Please title this as a Master Traffic Impact Study

Falcon Fields
Traffic Impact Study
(LSC #184560)
October 18, 2019

Add PCD File No. CR191

Conceptual Site Plan

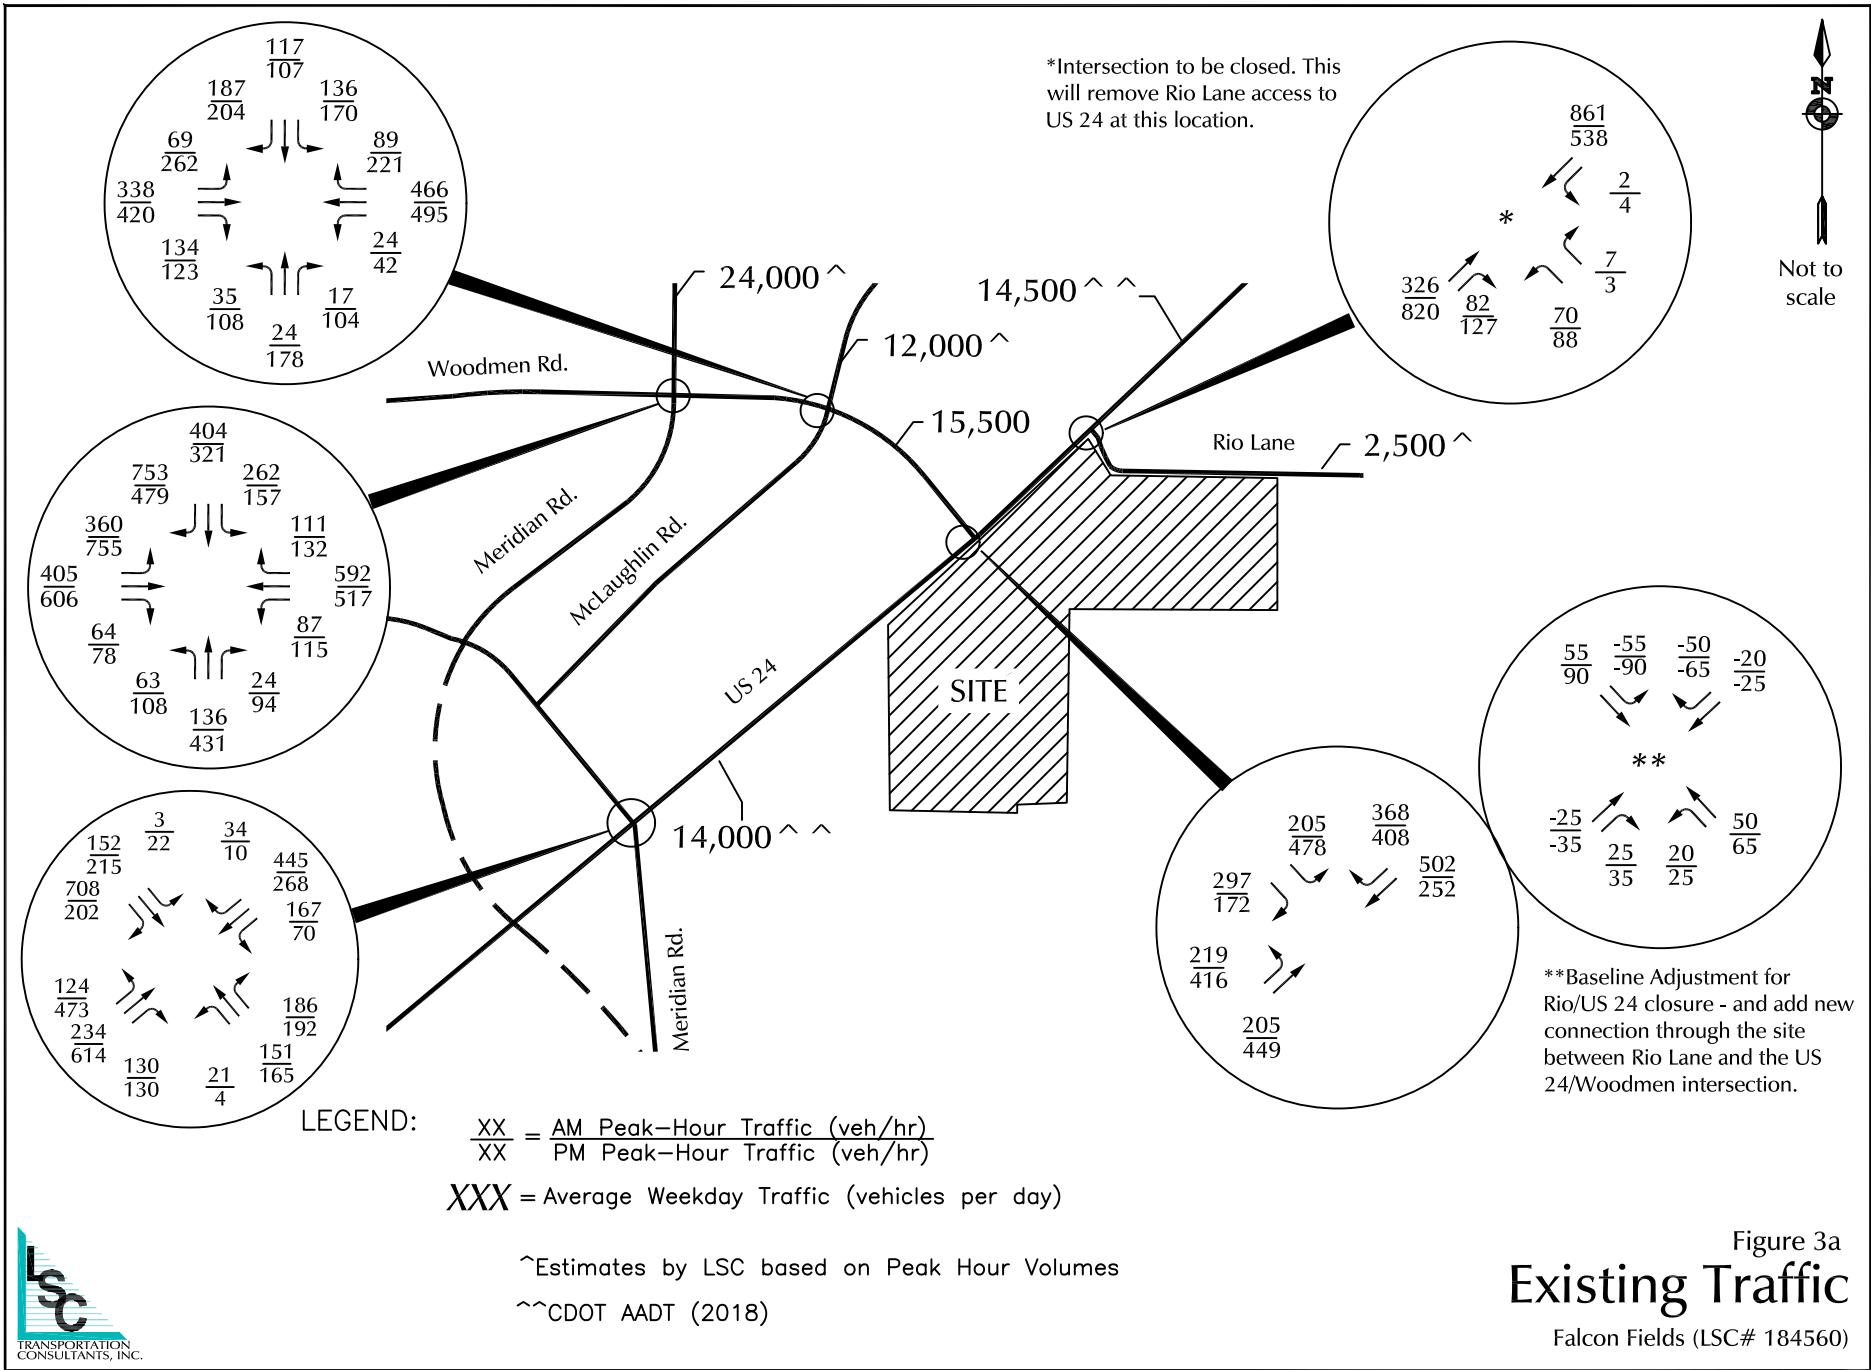
The conceptual site plan also show additional roads that would connect to the west in the future. Please include these in your narrative and also indicate the anticipated classification of these roads.

The conceptual site plan also shows storage units. Please include this in your trip generation estimate.

Figure 4
Directional Distribution

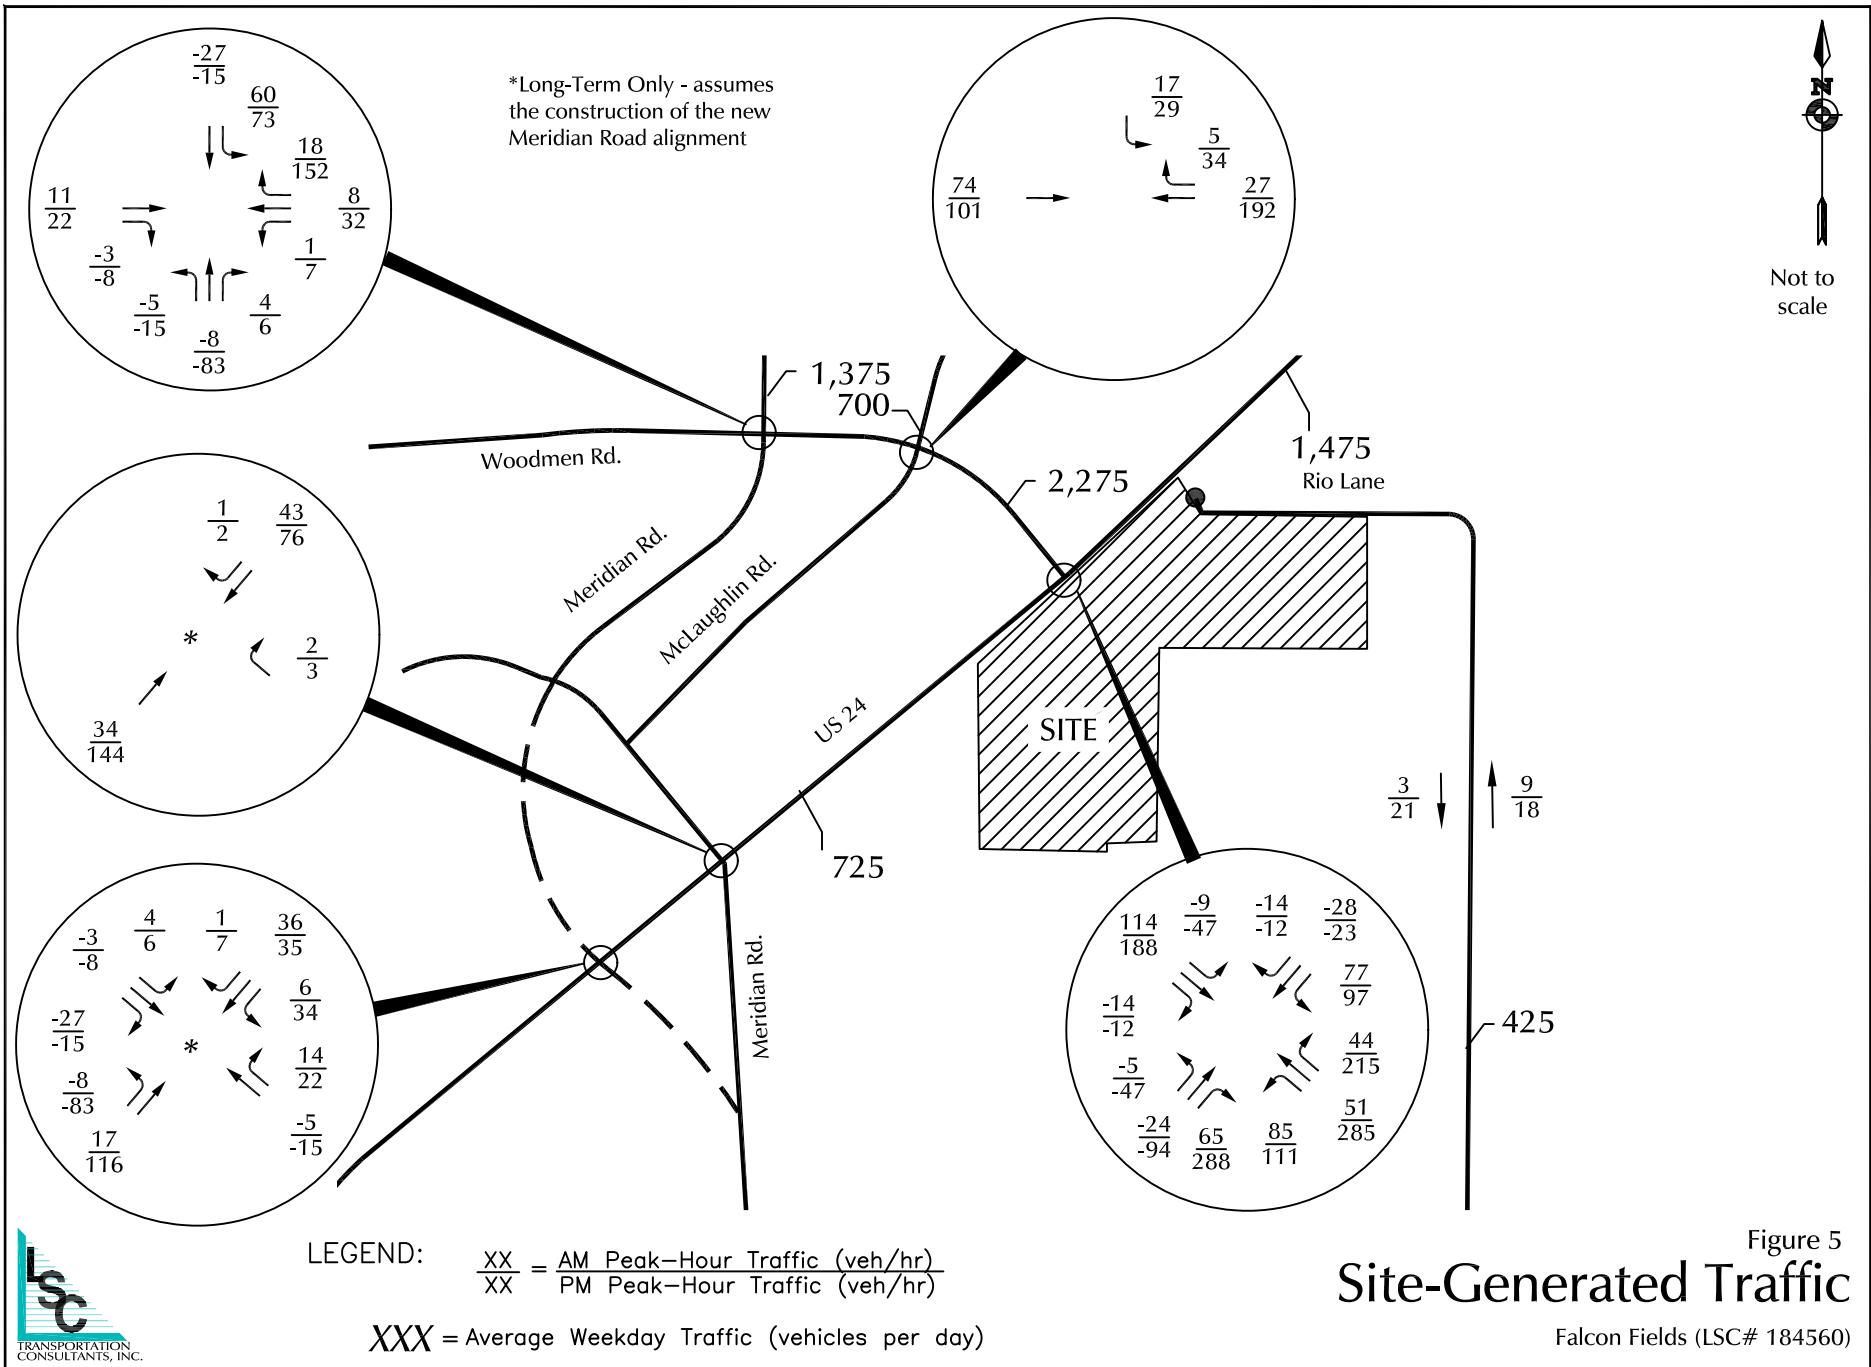
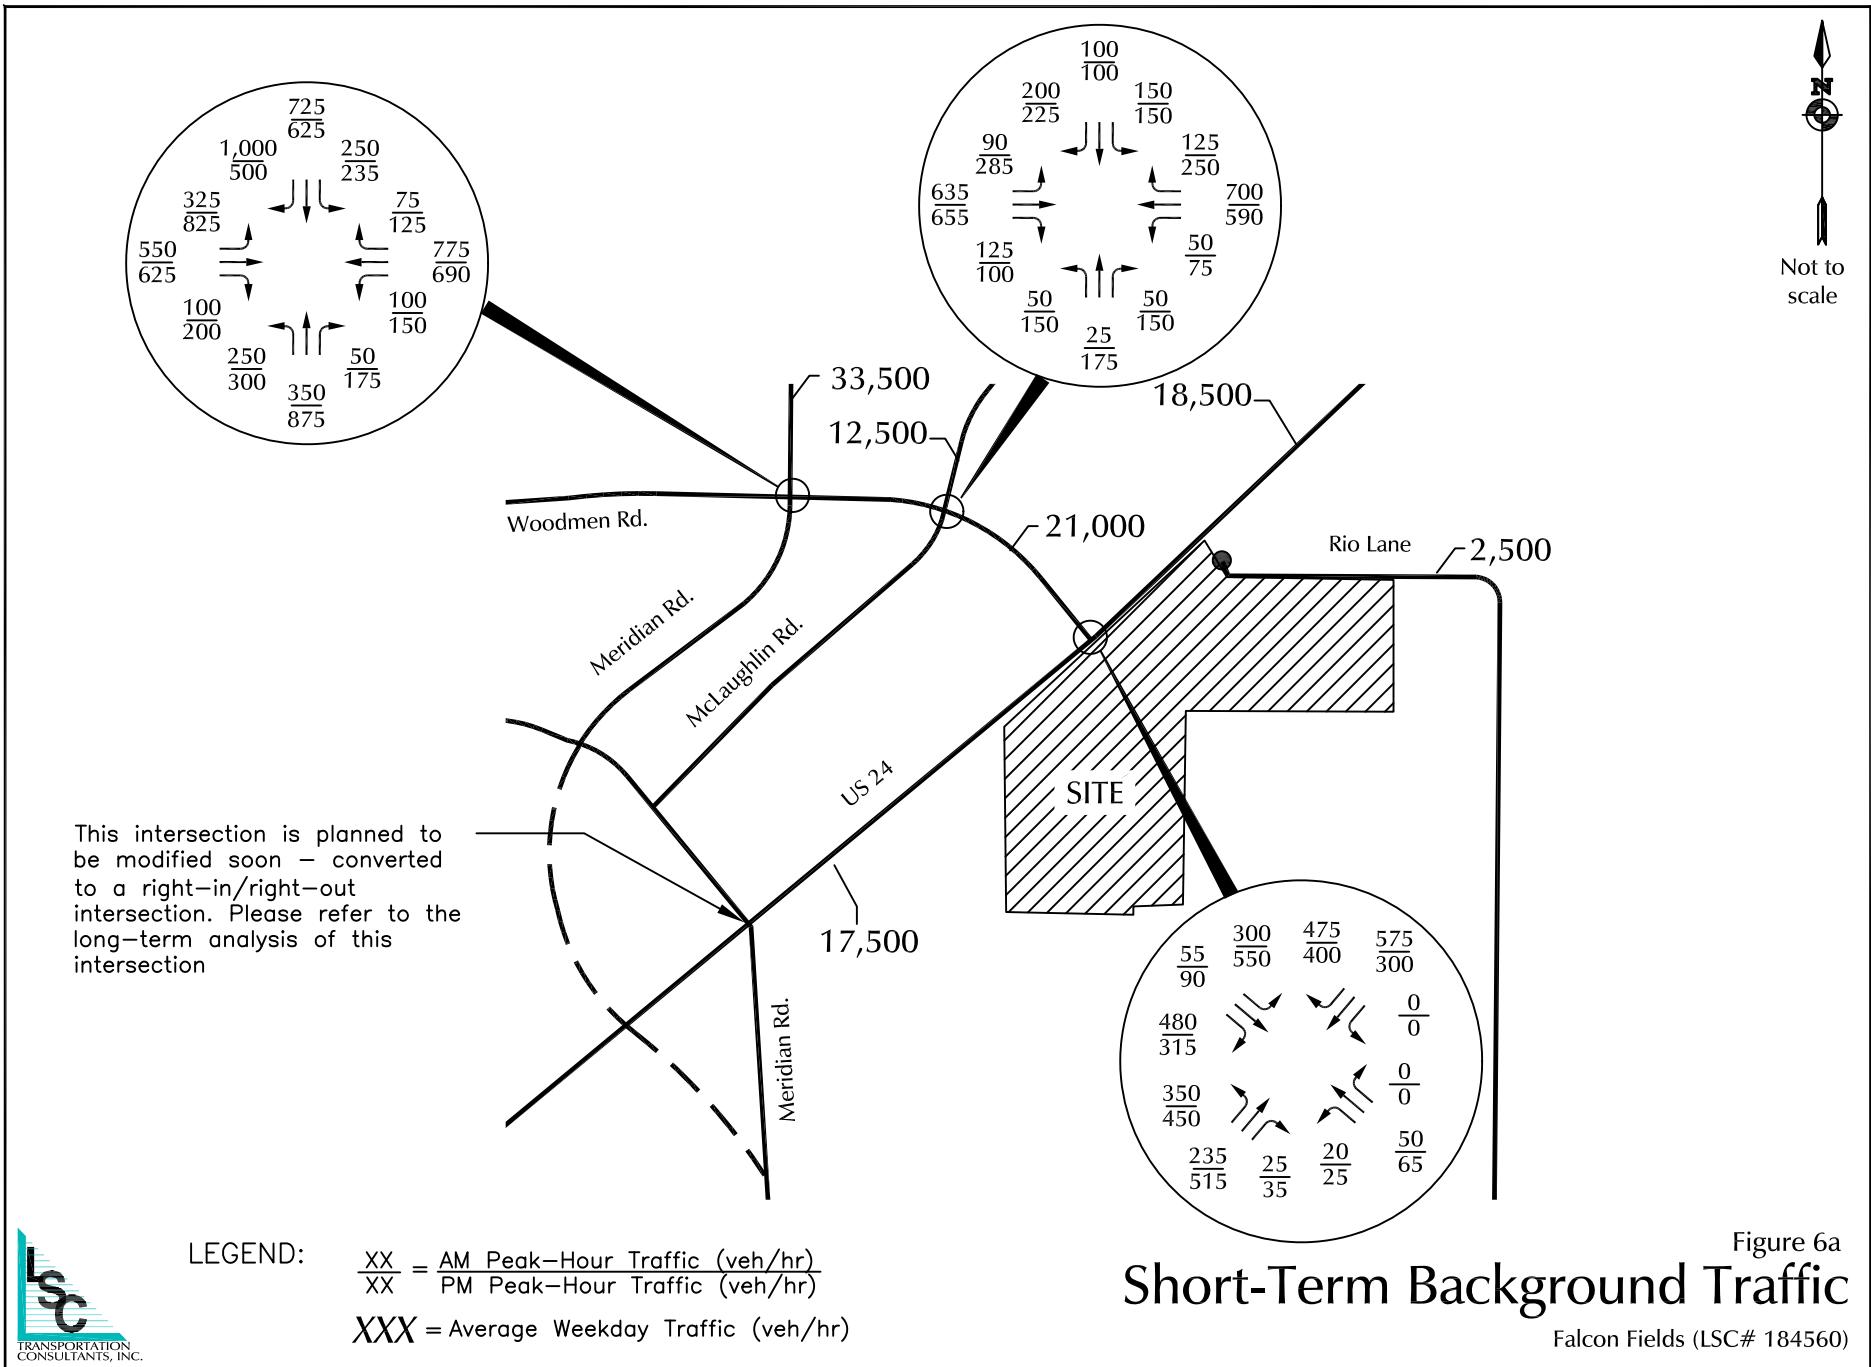
Please also include in the narrative the other distribution estimates shown in figure 4 with your reasoning for the estimates. Also see comment on figure 4.
